Your ref: 3/2015/0734

Date: 20th October 2015

Planning Application 3/2015/0734: Conversion of barn to form one dwelling; New Hall Barn Ribchester Road Clayton le Dale PR3 3ZQ

north elevation
scale 1:100

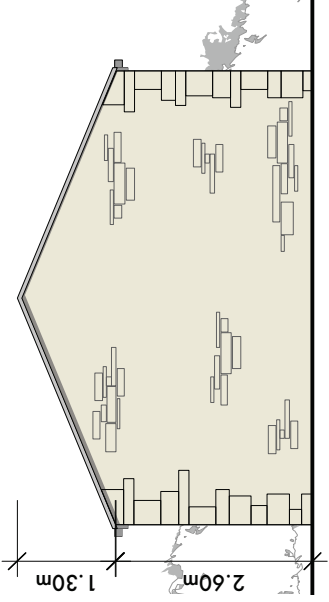
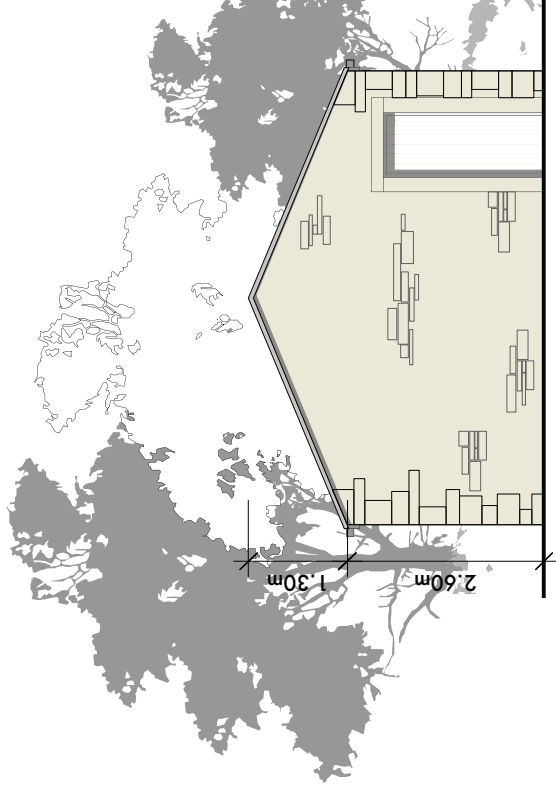
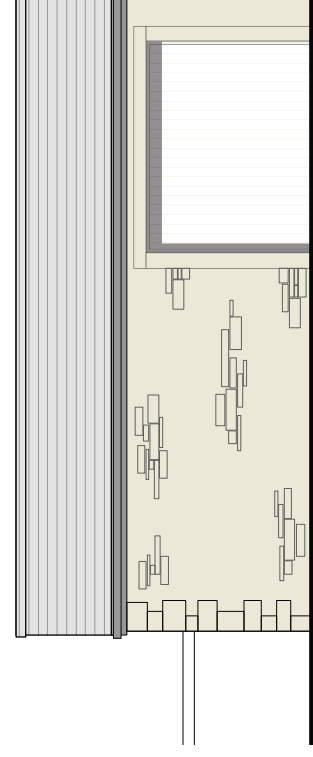
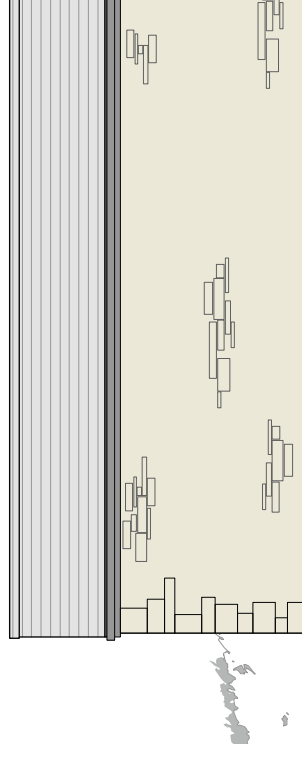
The second design issue of concern is the substantial alterations proposed to the northern gable end of the original barn. The removal of the later lean-to extension here is acceptable, but the proposed large gable window is a different matter. The insertion of this window will make a considerable change to this elevation of the building, removing much original fabric including a set of three doorways at ground level in this gable. These doorways are shown on drawing 1471 / EX02 and illustrated as Figure 9 in the Heritage Statement. The Statement (p.11) confirms that these doorways formed the access to a shippon at this end of the building and, with the central cart-entry bay and southern storage areas, mean that this barn is an example of the Lancashire Combination Barn type.

The externally-visible feature that makes it clear that this is specifically a Lancashire Combination Barn is the location of these doors in the gable end and it is proposed to remove these. This loss will mean that, with the necessary changes to the interior, this part of the building will no longer be interpretable – which is as noted above "*of most significance*". This aspect of the changes proposed is not considered in the Heritage Statement, although a brief justification for the new gable window is presented in section 4.3.3 where it is noted that retaining the openings was an option, but that this was discarded as the bases of the doors would have been obscured. The alternative which is proposed, the complete removal of the doors and surrounding masonry, is considered to have an unacceptable impact on the historic character of the building. It is recommended therefore that this detail is removed from the proposals.

drq.no. 1471 / EX02<sub>rev.</sub> A

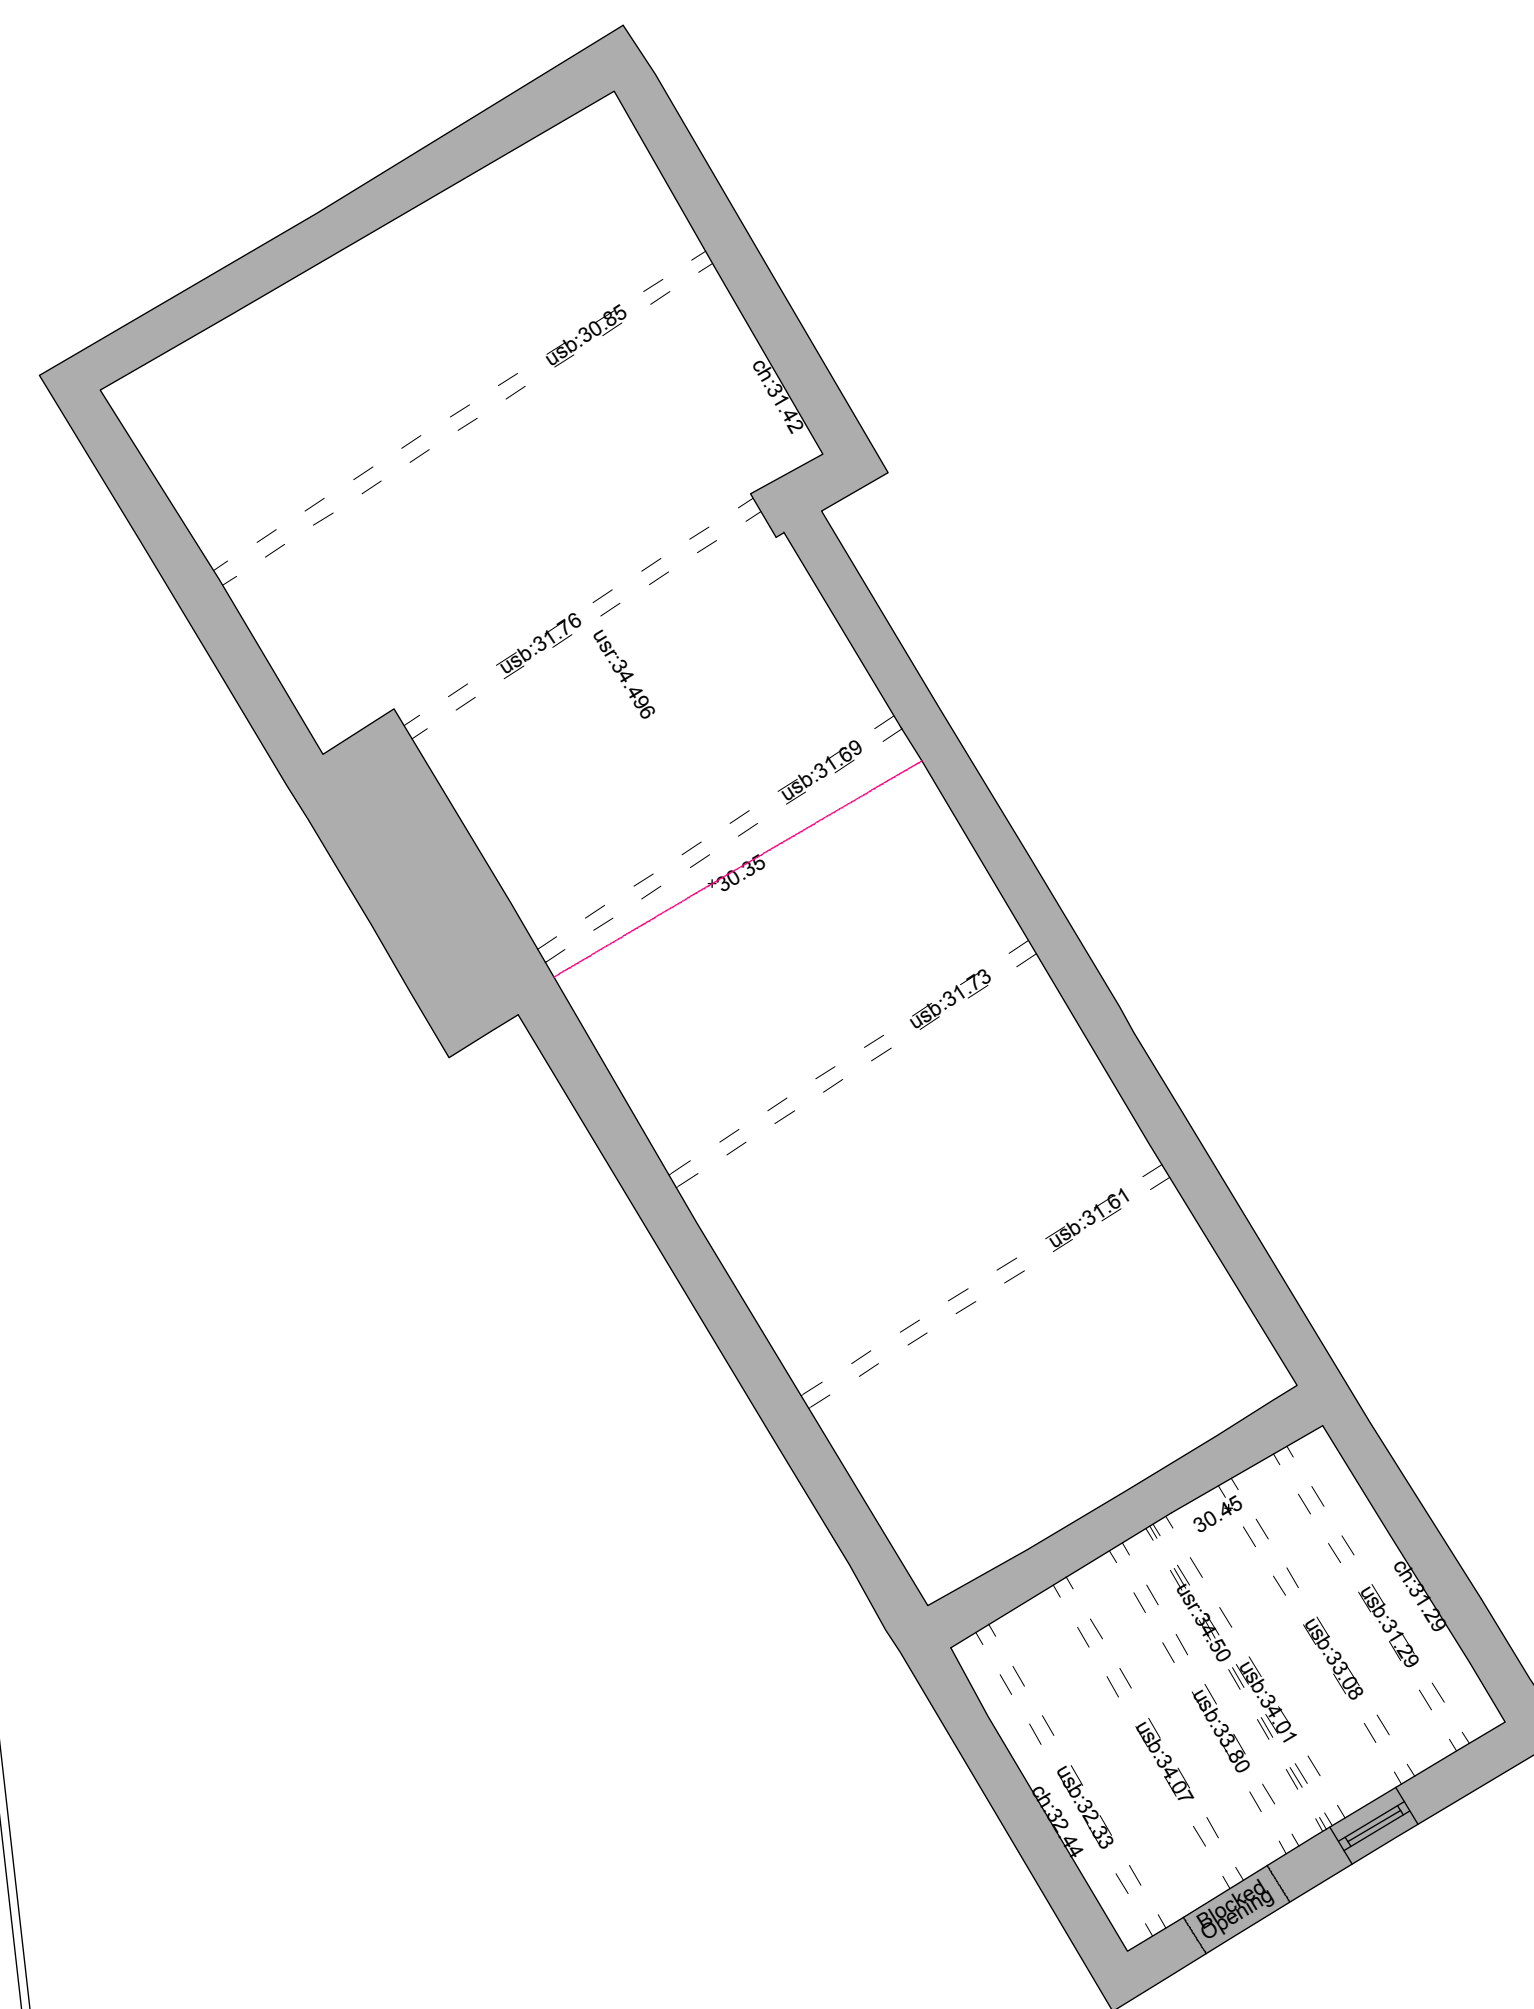
Whilst we would not object in principal to the conversion of this structure to domestic use, there are some items of concern in the detail of the design which may have an unacceptable impact. The first of these is the impact of the proposals on the existing roof structure in the main barn. The Heritage Statement illustrates these in Figure 10, titled "*Interior of original barn ... original trusses with trenched purlins, struts and upper ties*" and again notes their originality in section 3.2.1, where it also states that this section of the building is of 18th century date. The locations of these five trusses is set out in drawing 1471 / EX02. The significance of the roof structure is set out in section 3.3:

Proposed Plans

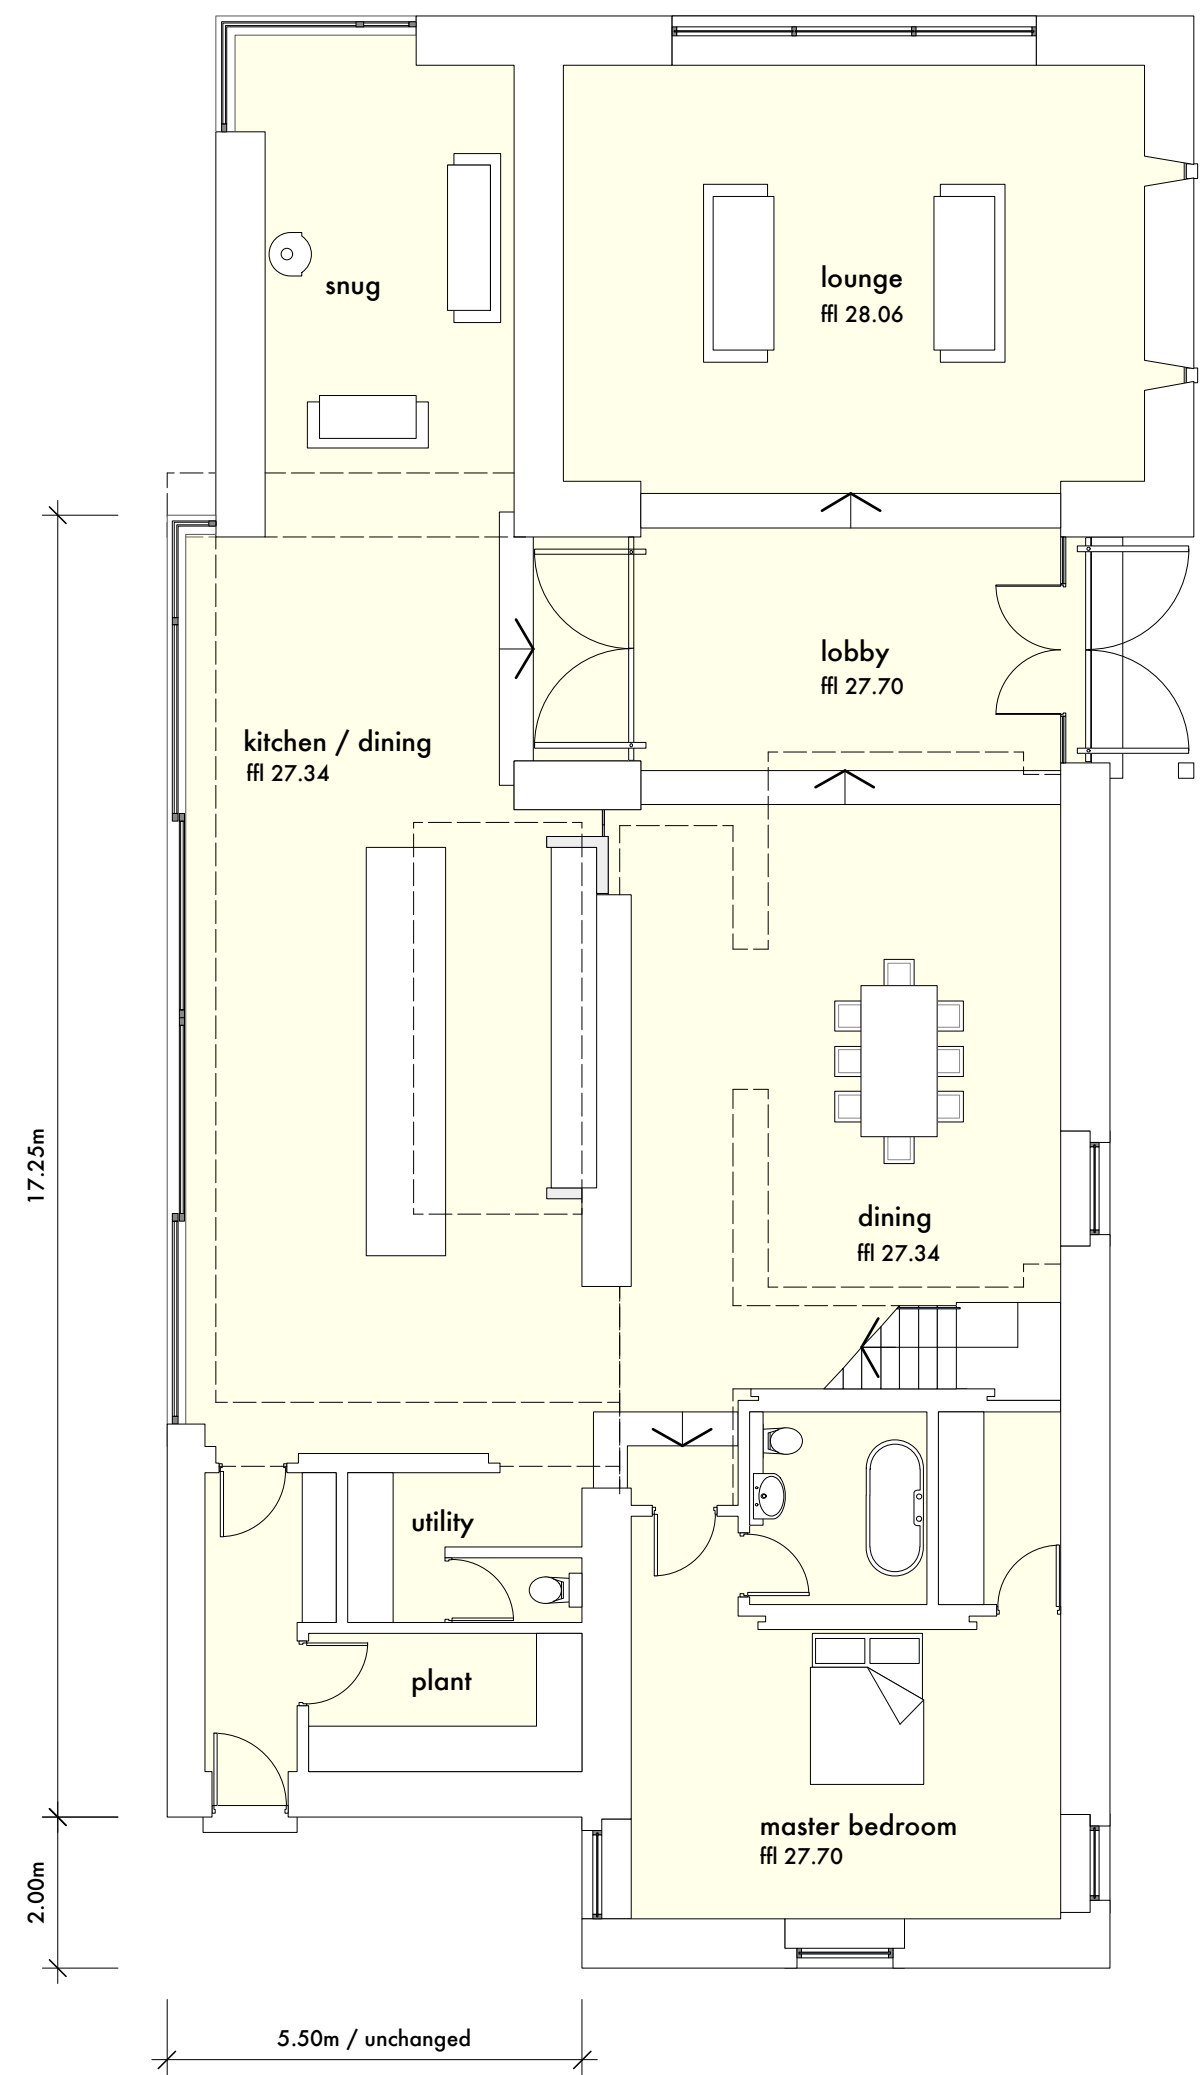
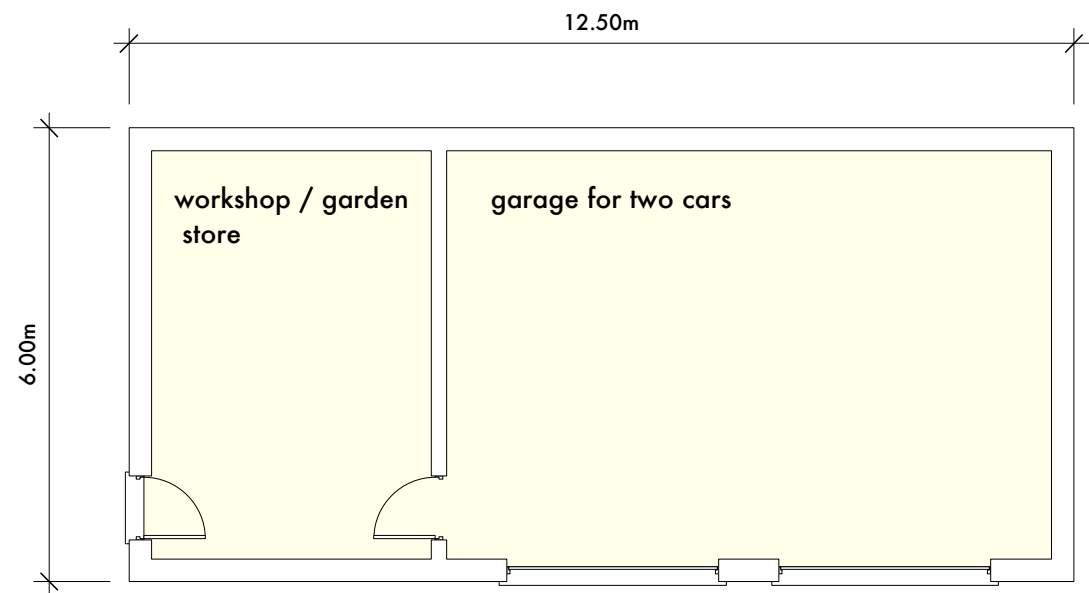
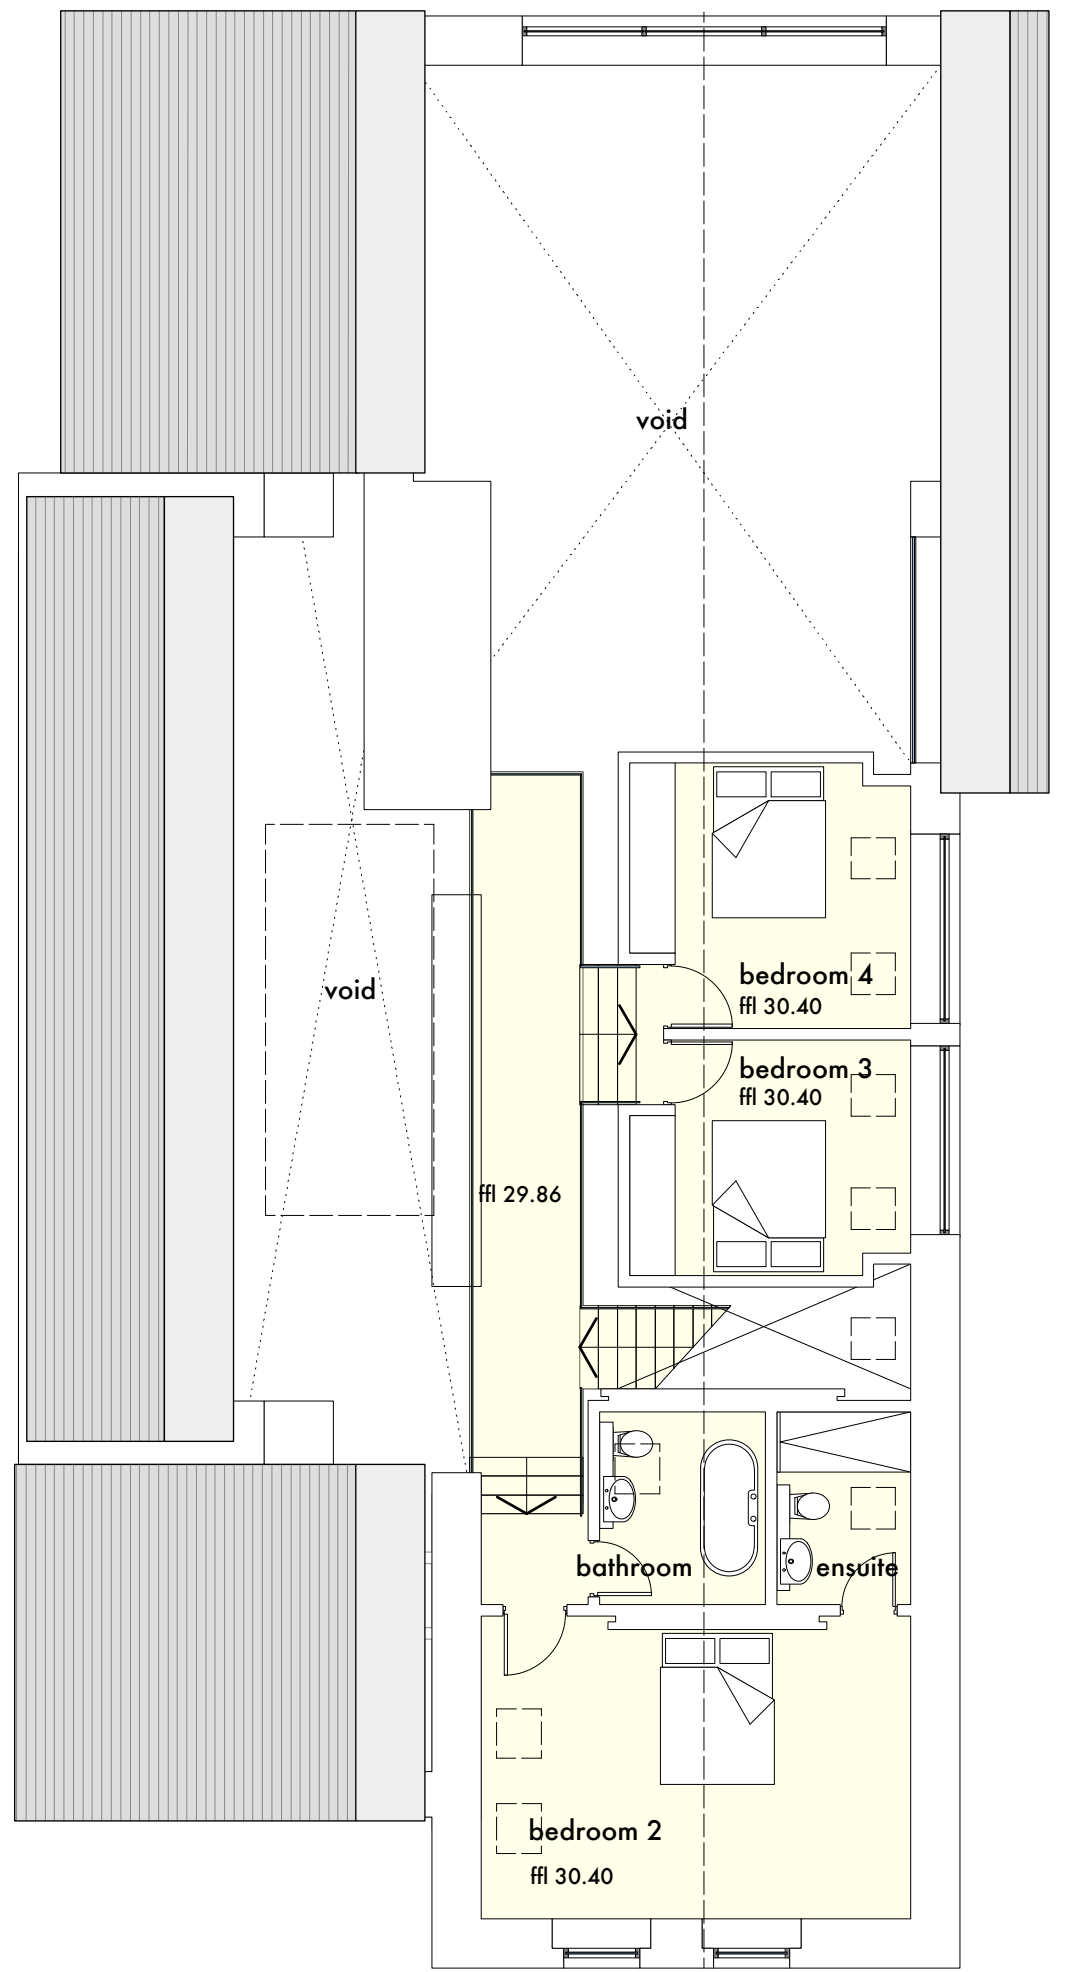
Unfortunately the trusses are not shown on the proposed plans (drawing 1471 / PL 00) or elsewhere and it is difficult to see how the southern three trusses can be incorporated within the proposals for the new first floor in that part of the building without replacement or at least substantial alteration. This issue is not discussed in the heritage statement or the Design and Access Statement and the matter will need to be clarified with the applicants and an assessment of the impact of the proposals upon the historic roof structure made. This assessment should also look at the originality of the purlins, common rafters and roof coverings, and the impact of the proposals upon them. If any of the original timbers cannot be retained, consideration should be given to detailed recording (below) and perhaps also their dating by dendrochronology.
